# RESPONSE TO SUBMISSIONS

LANG WALKER AO MEDICAL RESEARCH BUILDING – MACARTHUR

SSD-17491477

MARCH 2022

Figure 12: Cycling Paths (Source: Transport for New South Wales Cycle Finder)

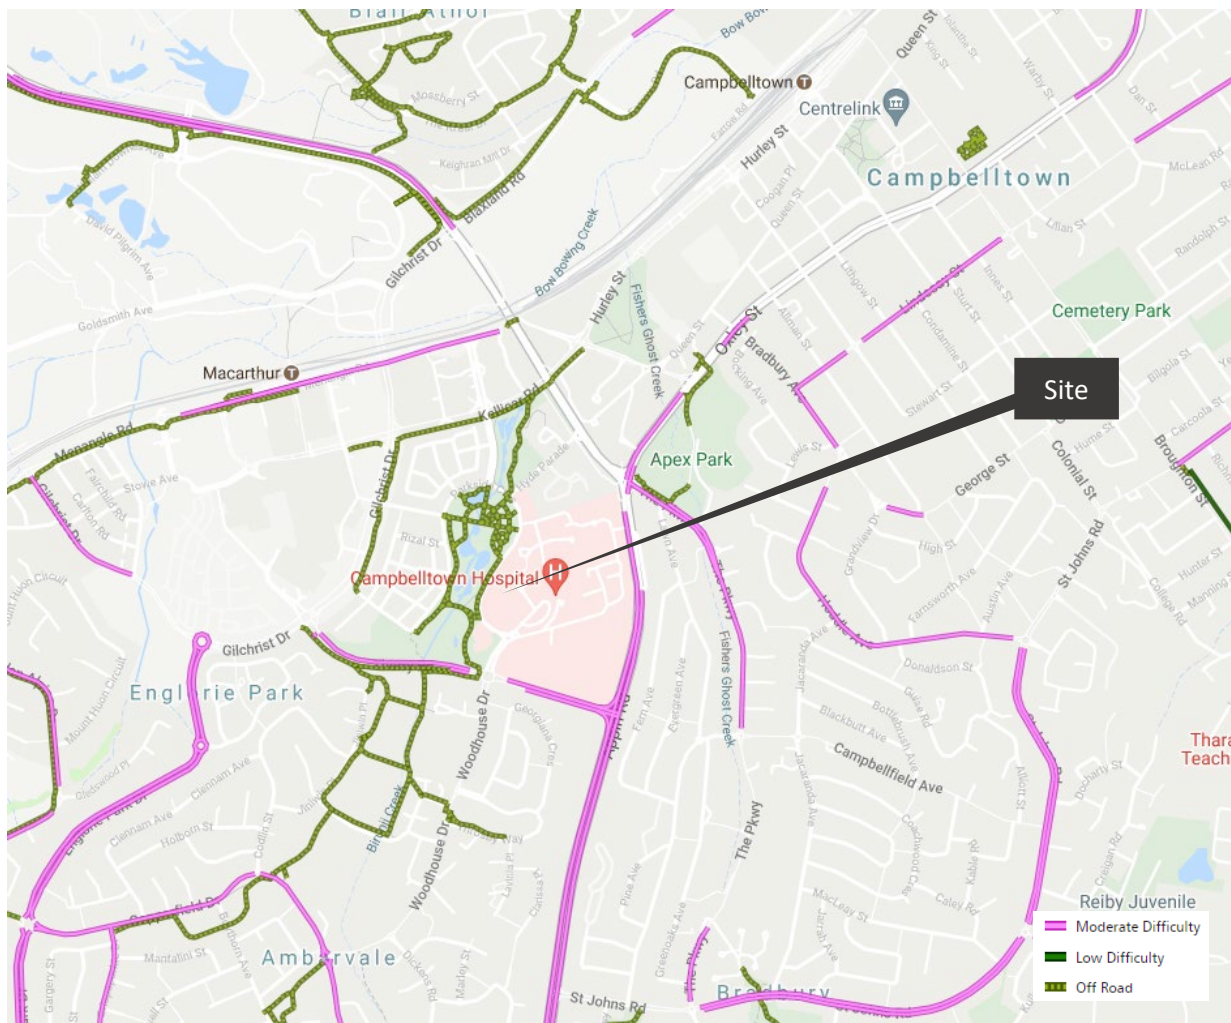
FEEDBACK	RESPONSE
DEPARTMENT OF PLANNING, INDUSTRY AND ENVIRONMENT (DPIE)	B. Amended plans are to be submitted displaying the location of visitor bicycle storage racks in vicinity of both the Parkside Crescent entrance and village green entrance.

Refer Appendix A, Page 2 for location of additional Bicycle Parking.

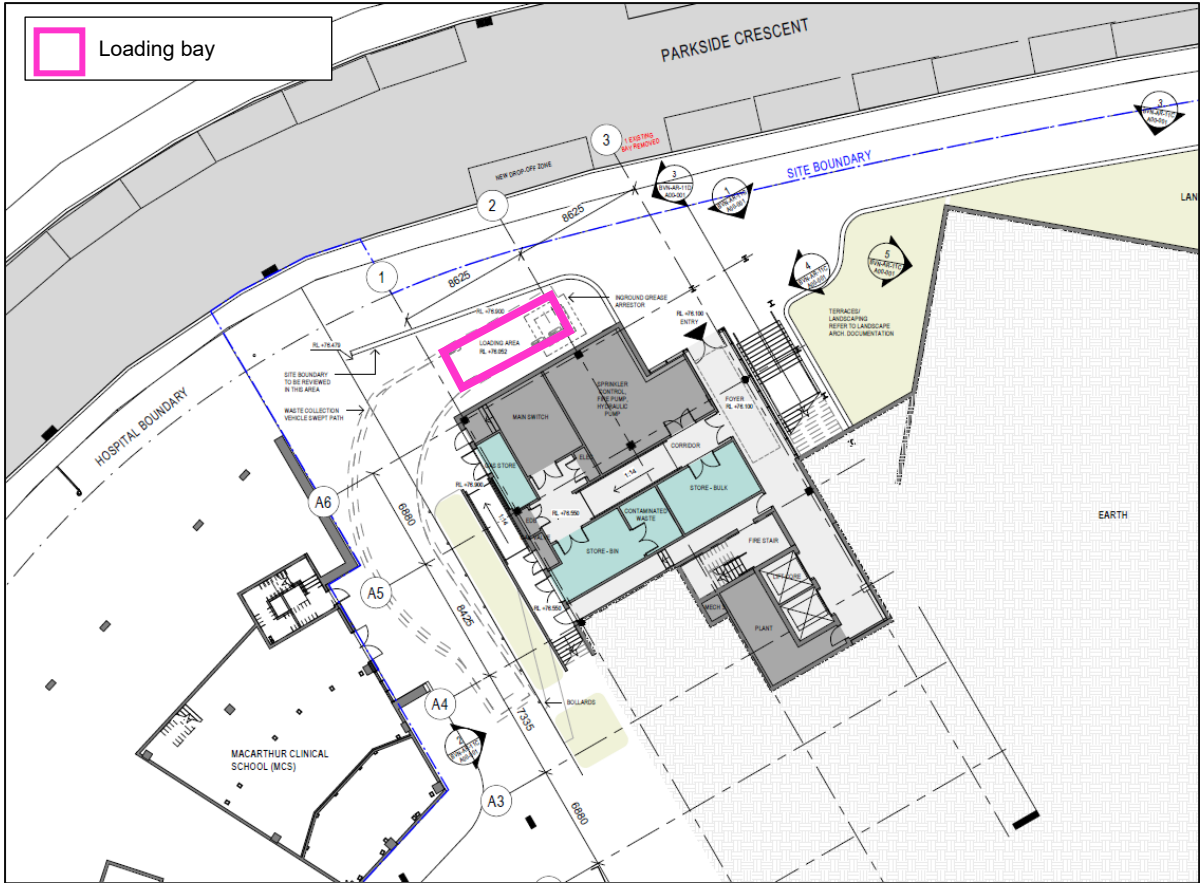
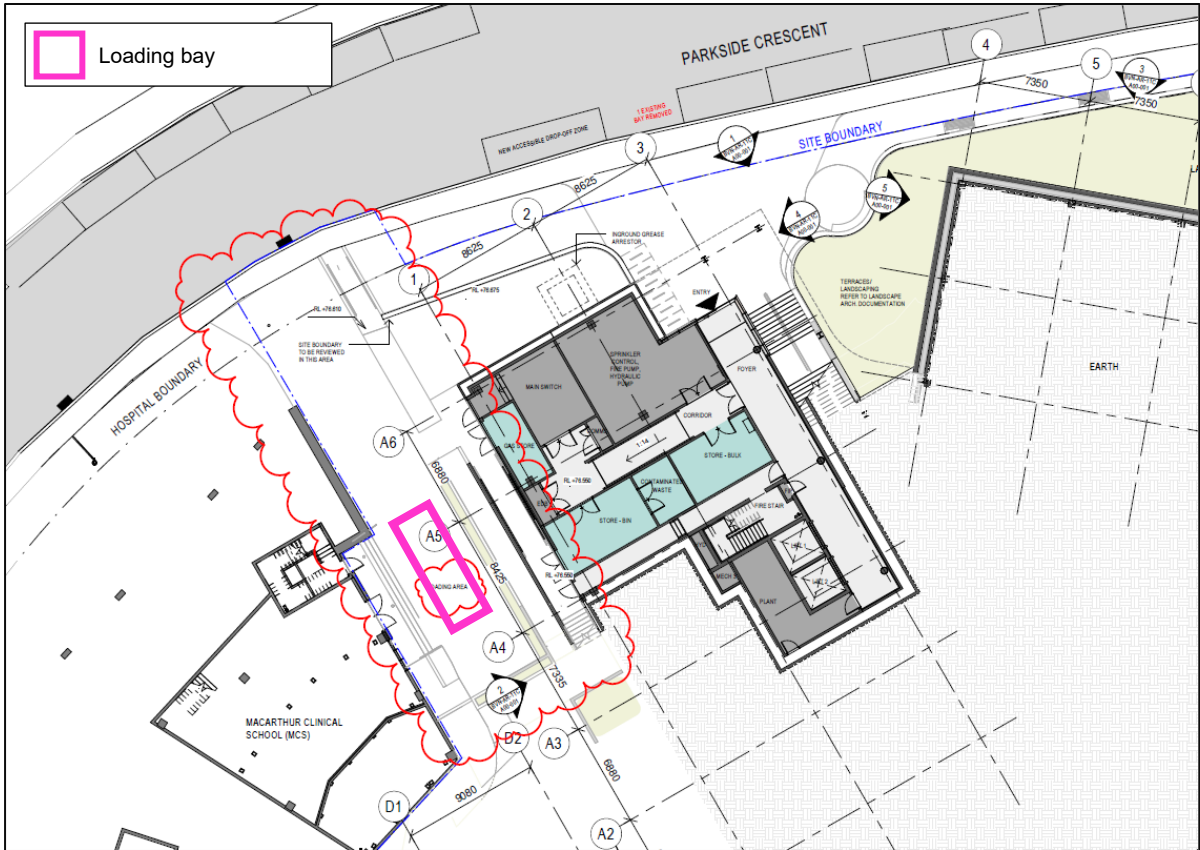
Council is of the view that the proposed loading area facing Parkside Crescent would not be the best location for loading from an aesthetic perspective. Council would appreciate if the loading area could be relocated so that it would not be visible from Parkside Crescent. The opportunity for the loading bay to be accessed from within the hospital site should be pursued, as this is a "back-of-house" activity that should not be located between the building and the street.

From a traffic management perspective, additional driveway access from Parkside Crescent should be avoided, as this would result in reduced on-street car parking, and would negatively impact on the safety of all road users. As stated above, the opportunity for the loading bay to be accessed from within the hospital site should be pursued.

The location of the loading bay has been adjusted to sit in the area indicated in Figure 1a. The hardstand area previously indicated as the loading bay must remain in order to facilitate the turning circle of waste management vehicles shown in the swept path on Figure 1b. The through site link has been retained through the use of ramps and walkways.

Refer Figure 1a for location of new loading bay and Figure 1b for Service vehicle Swept Path.

No additional driveway access is proposed. Driveway access between the proposed LWMRB site and Macarthur Clinical School (MCS) exists currently.

Refer to Figure 1b for proposed loading access to the LWMRB, updated to incorporate 'right in only' access and 'left out only' egress. In this scenario existing on-street parking is not impacted.
